PPR2619

Re: Letter of Intent for Site Development Plan – Rolling Meadows Substation Project

115/112.47KV
SITE PLAN

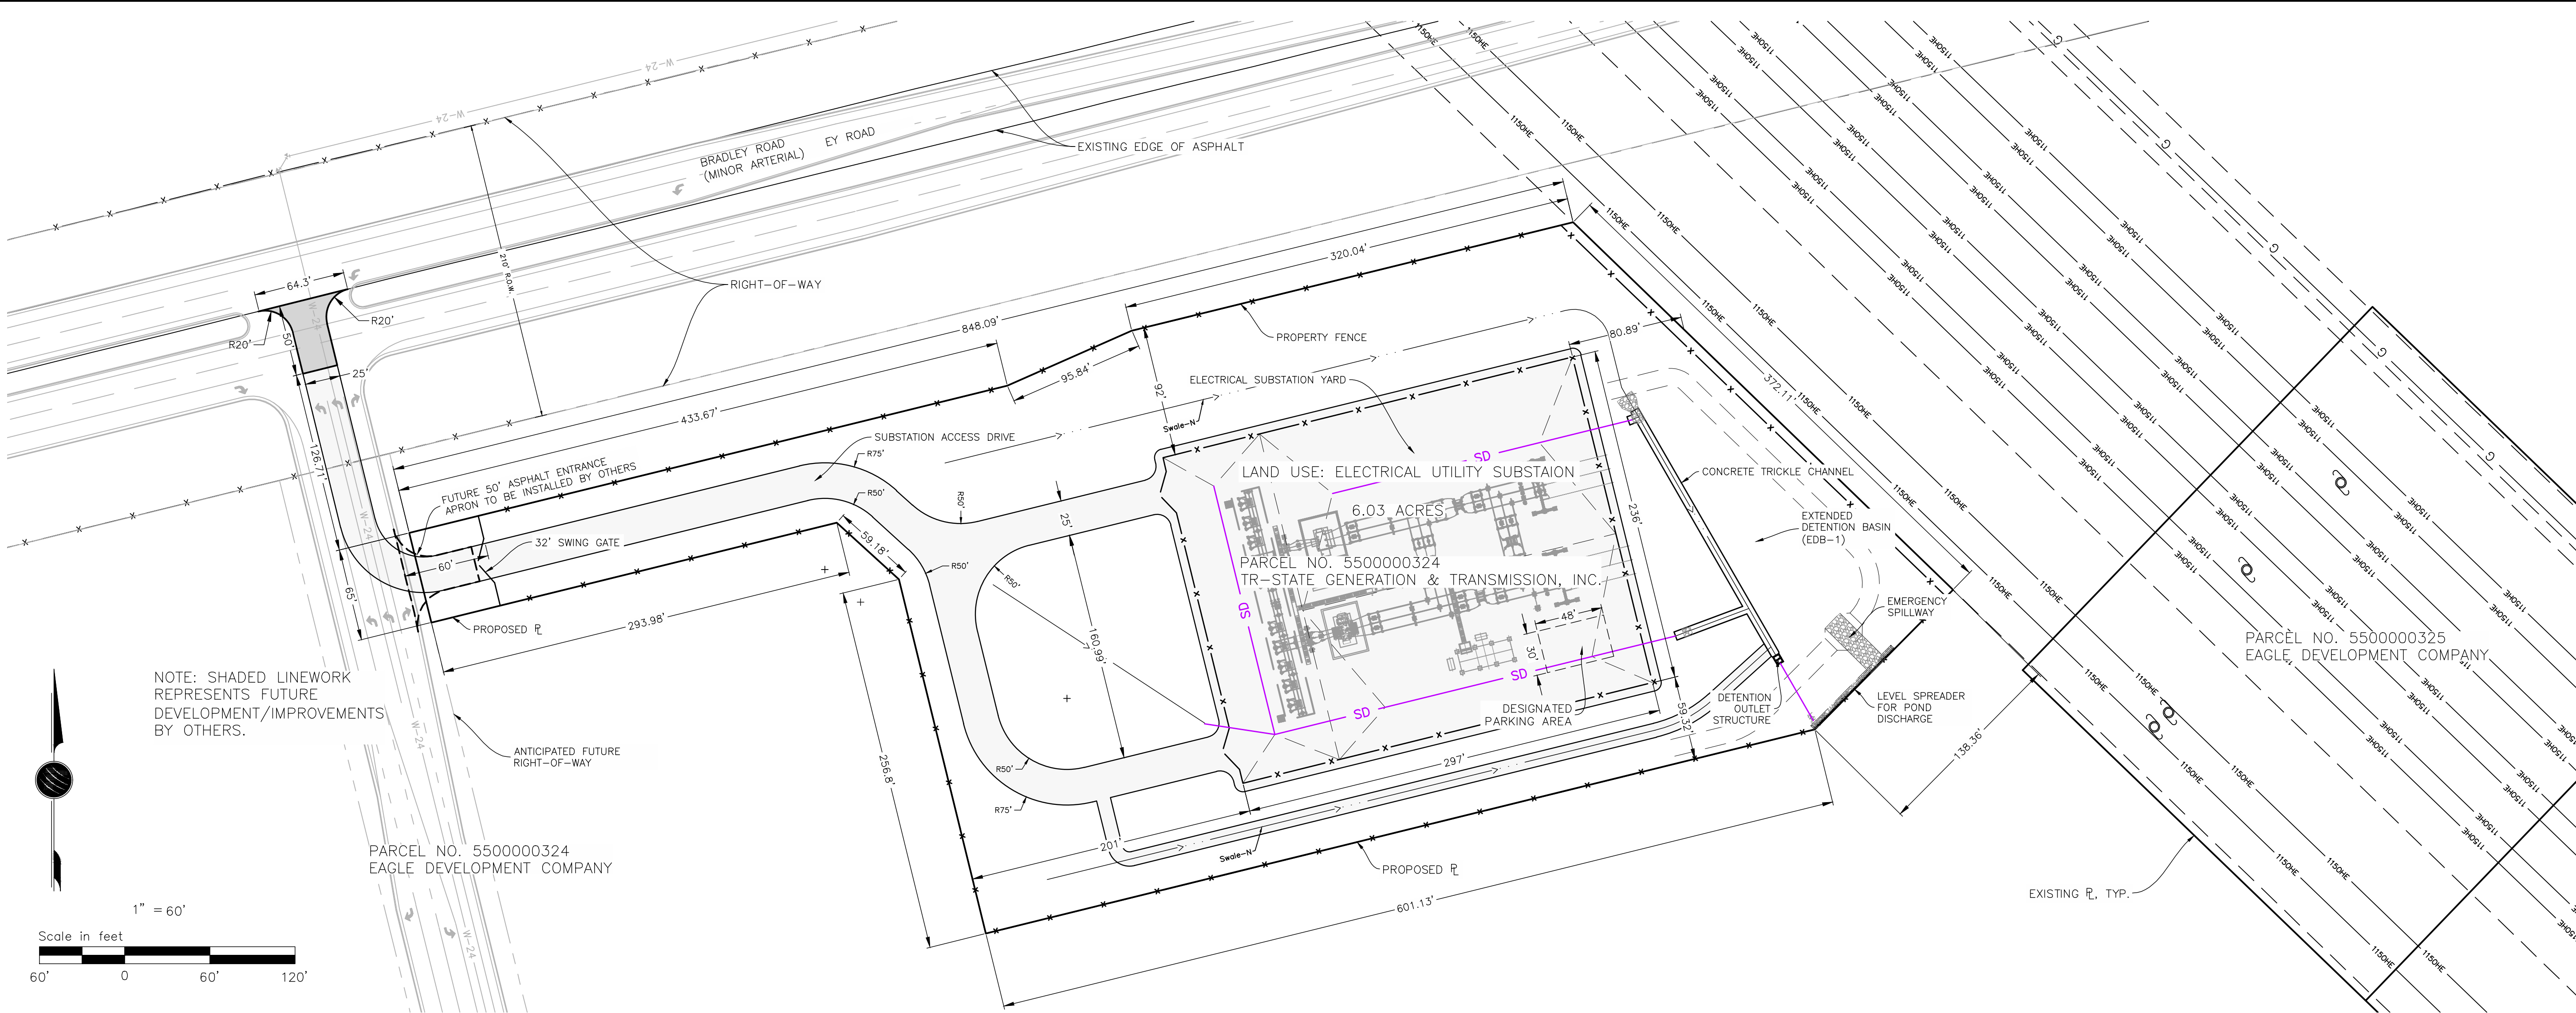
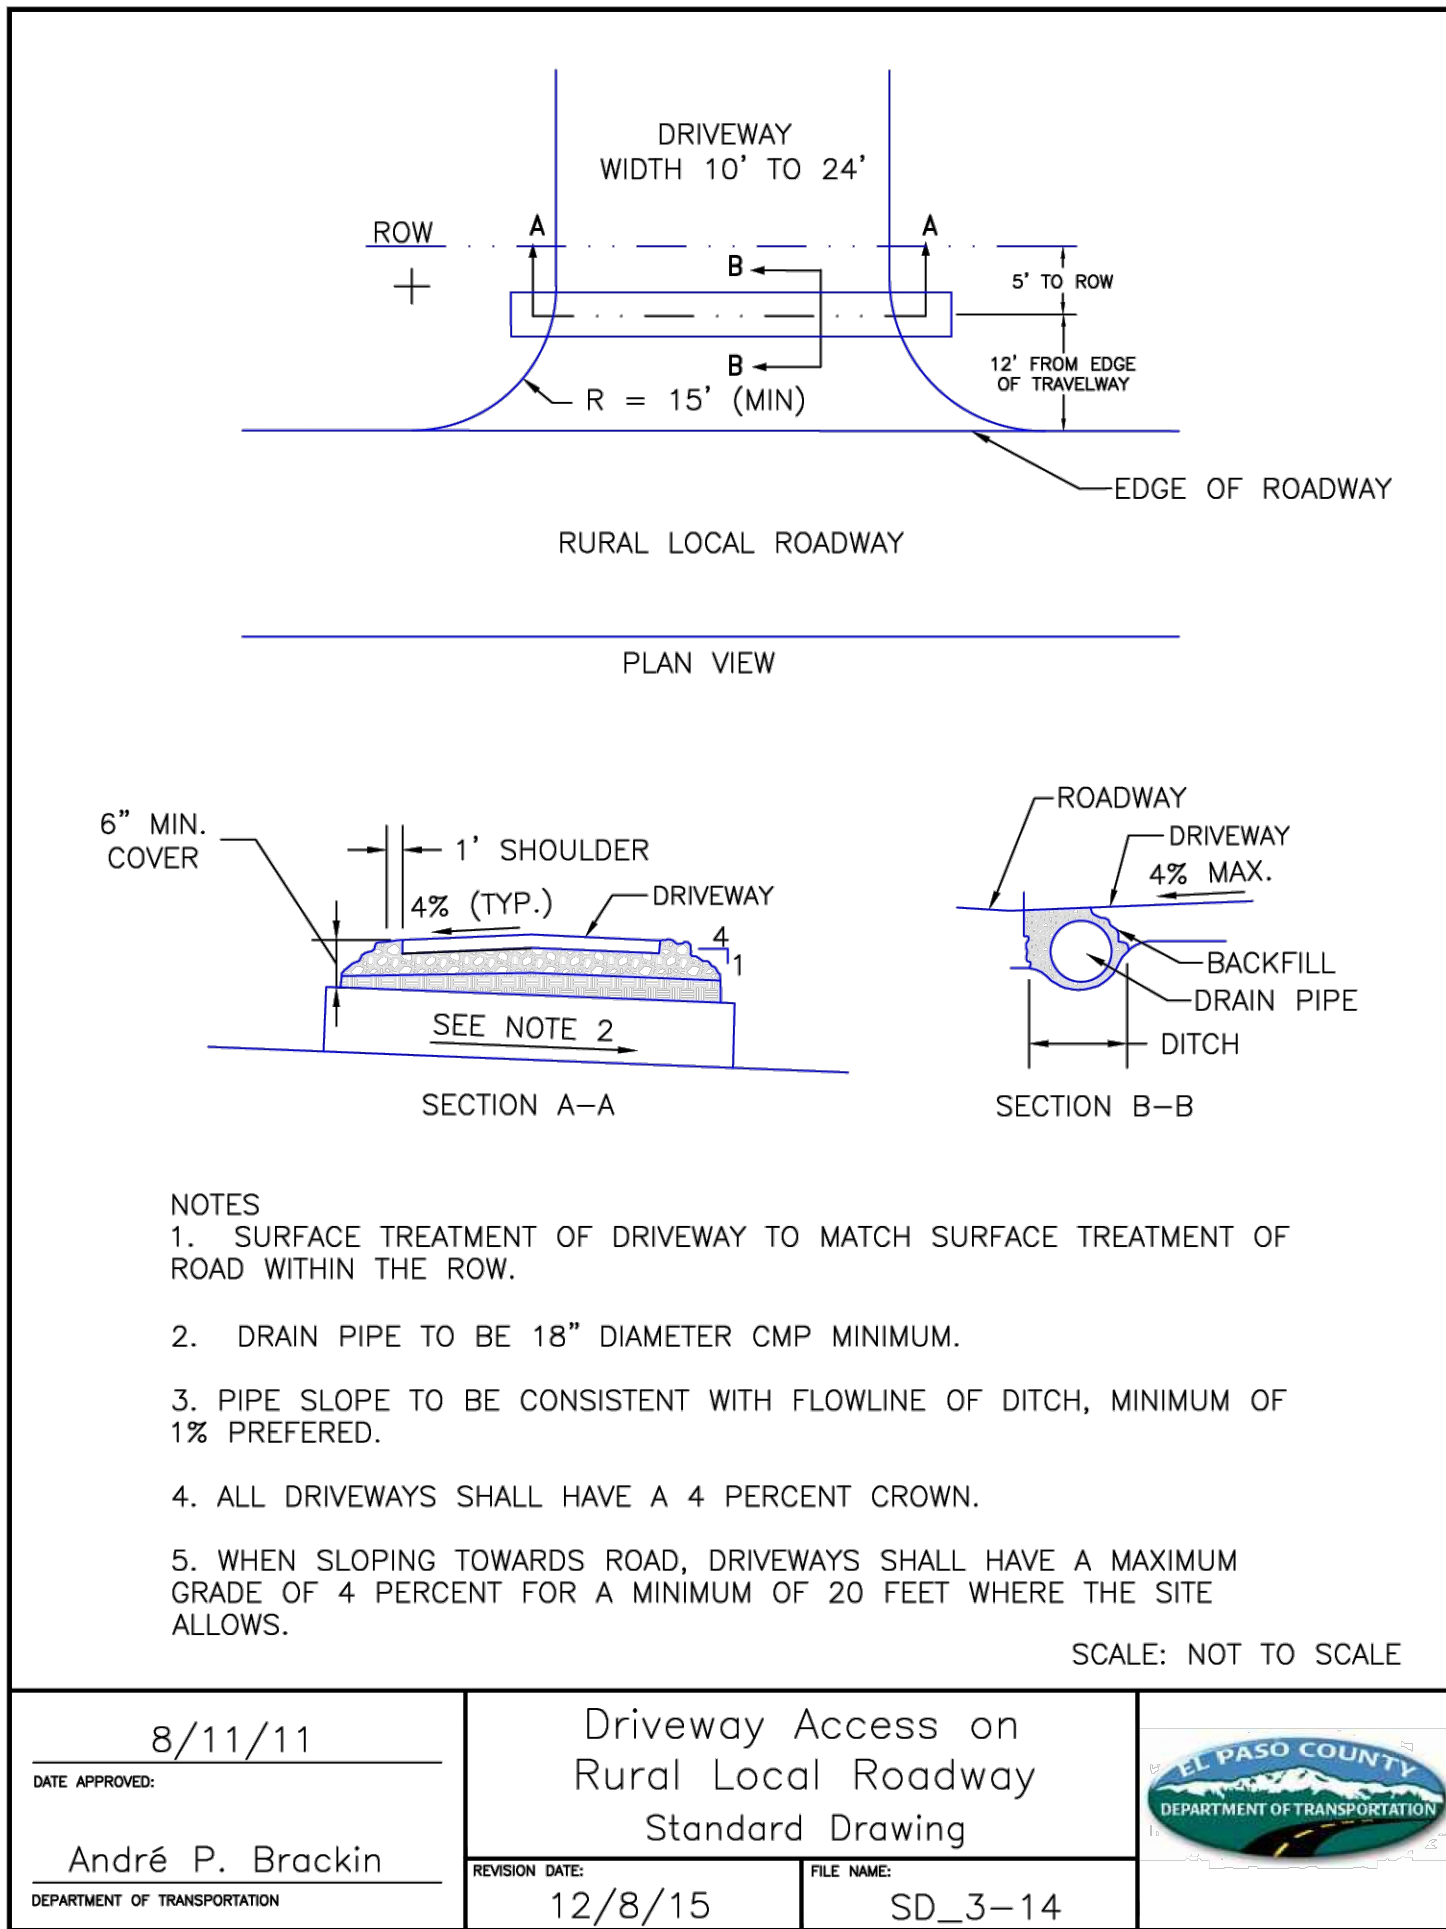
Parking still needs to be shown on plan (6.2.5 of Land Use Code)

Plans show road as being done with future development. Will the road be completed before the facility is operational? Address this and how access is achieved if road is not complete before facility is open.

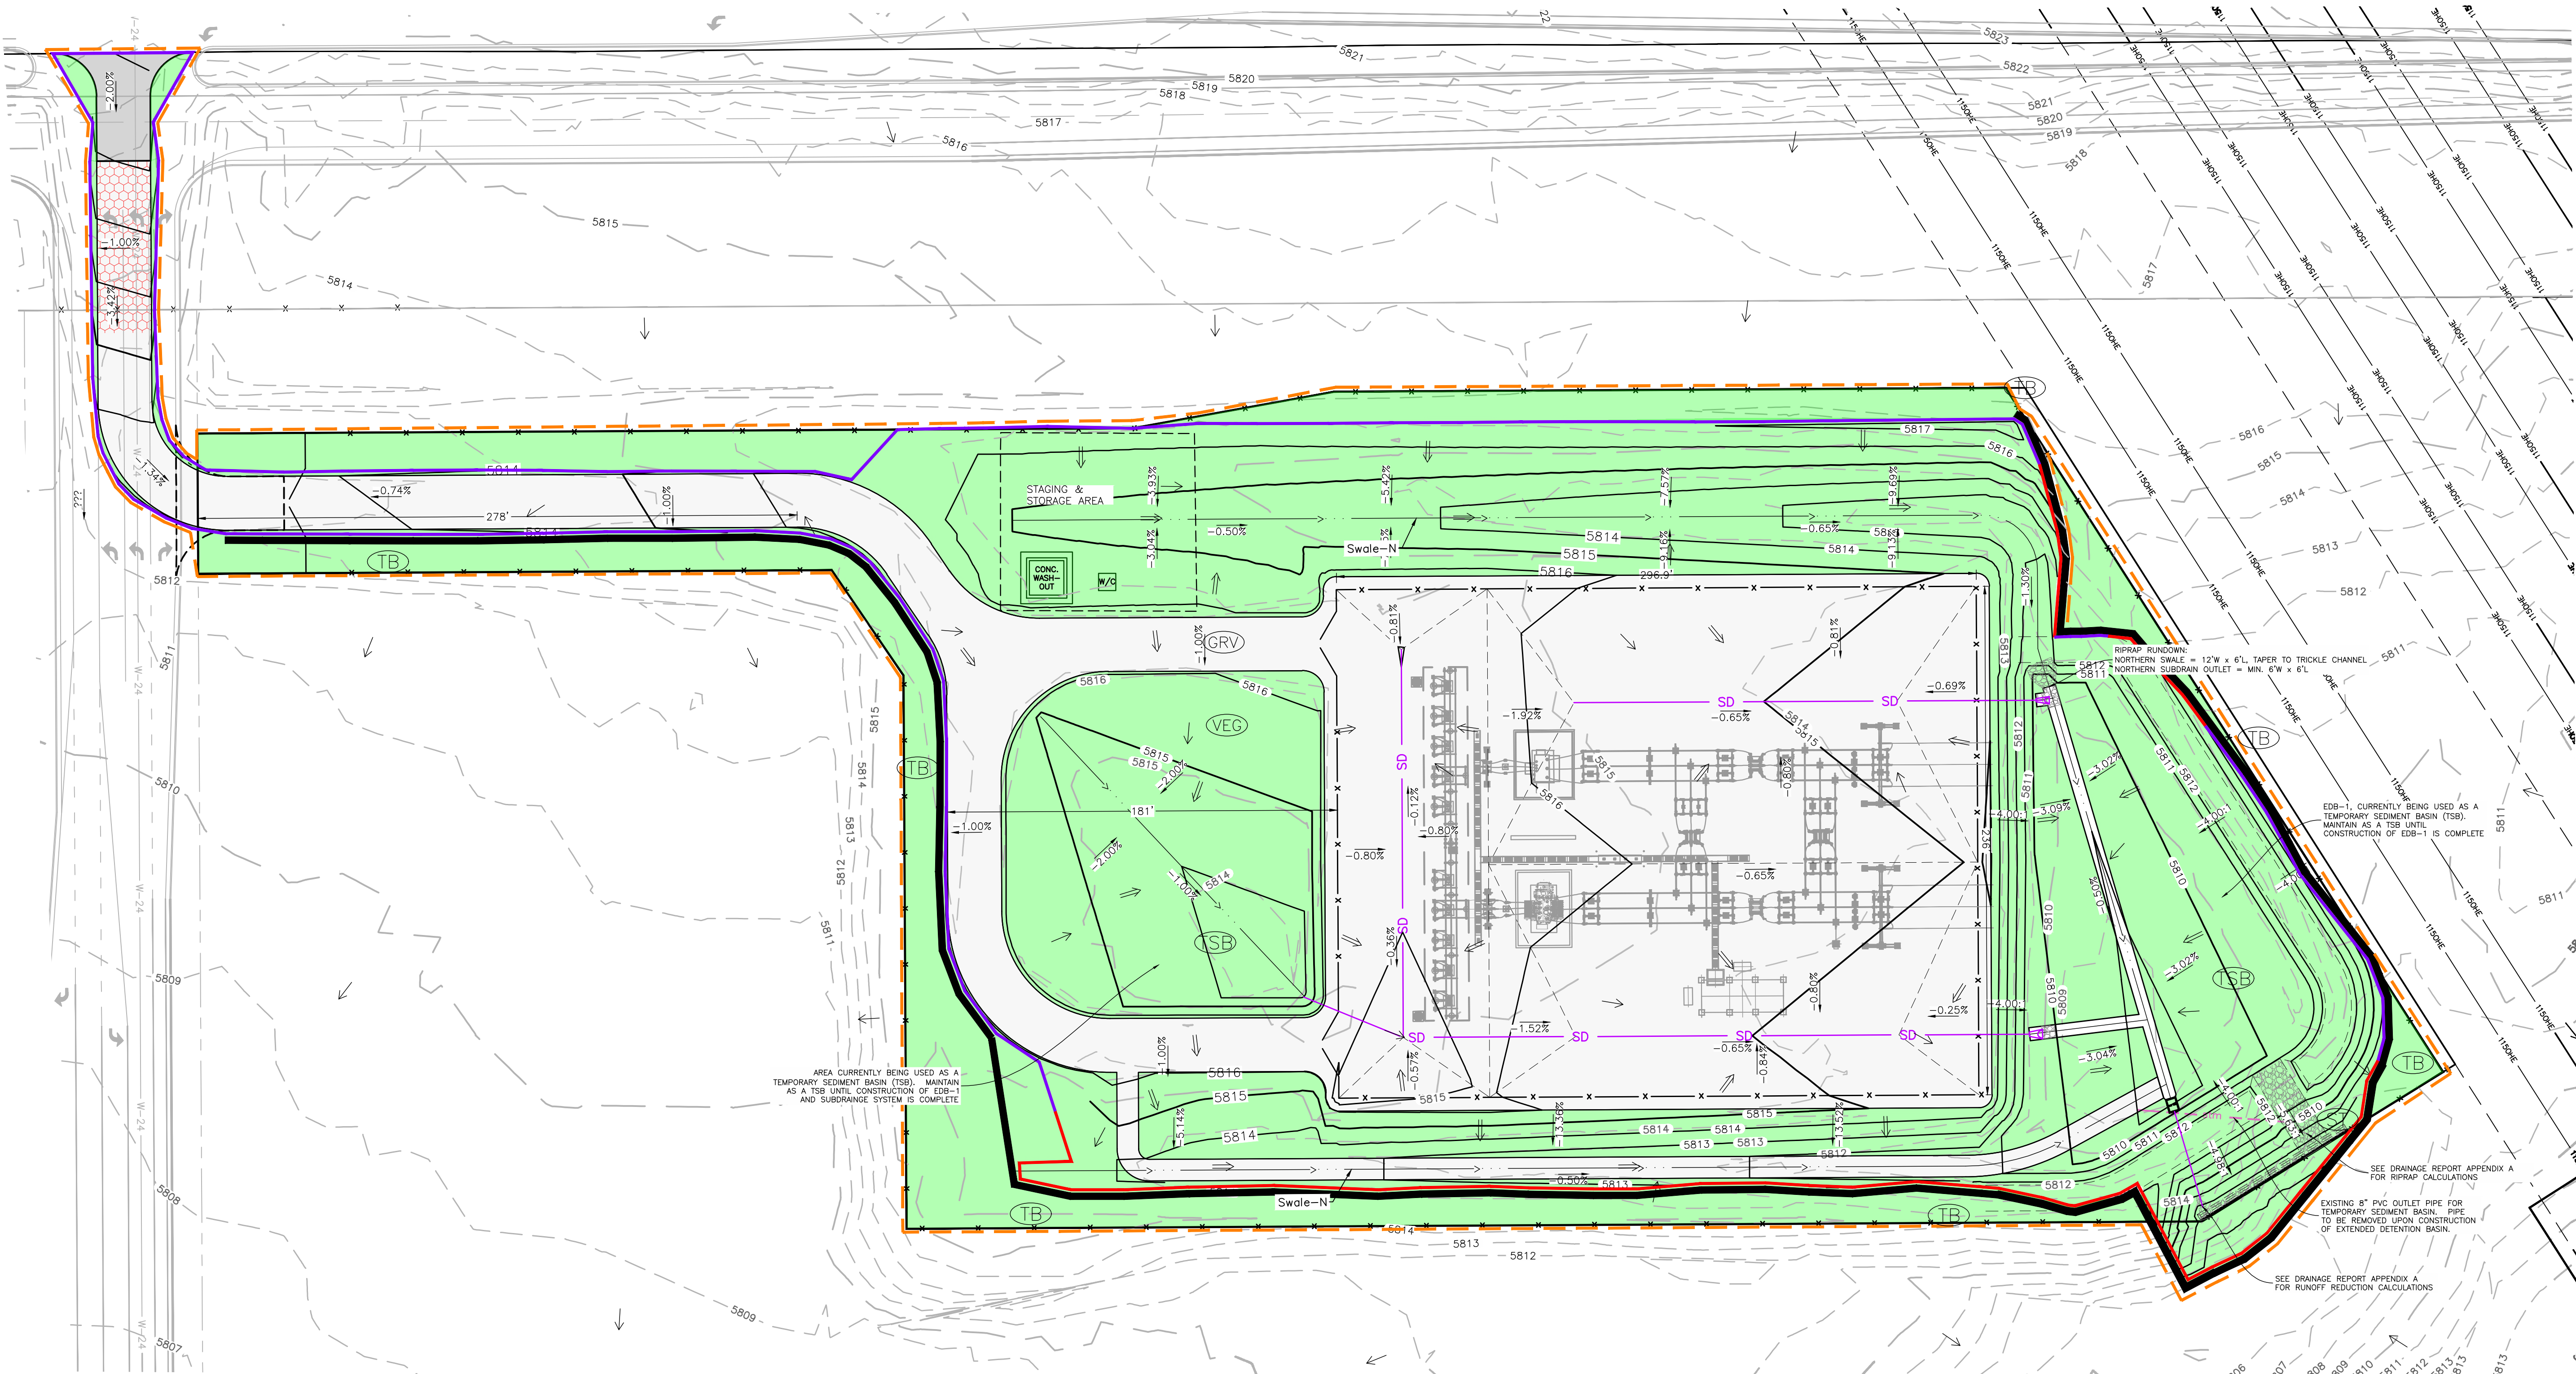
Unclear if landscaping is proposed with this submittal? GEC plan shows seeding but nothing else, landscaping not on FAE? Clarify timing of improvements and responsible parties.
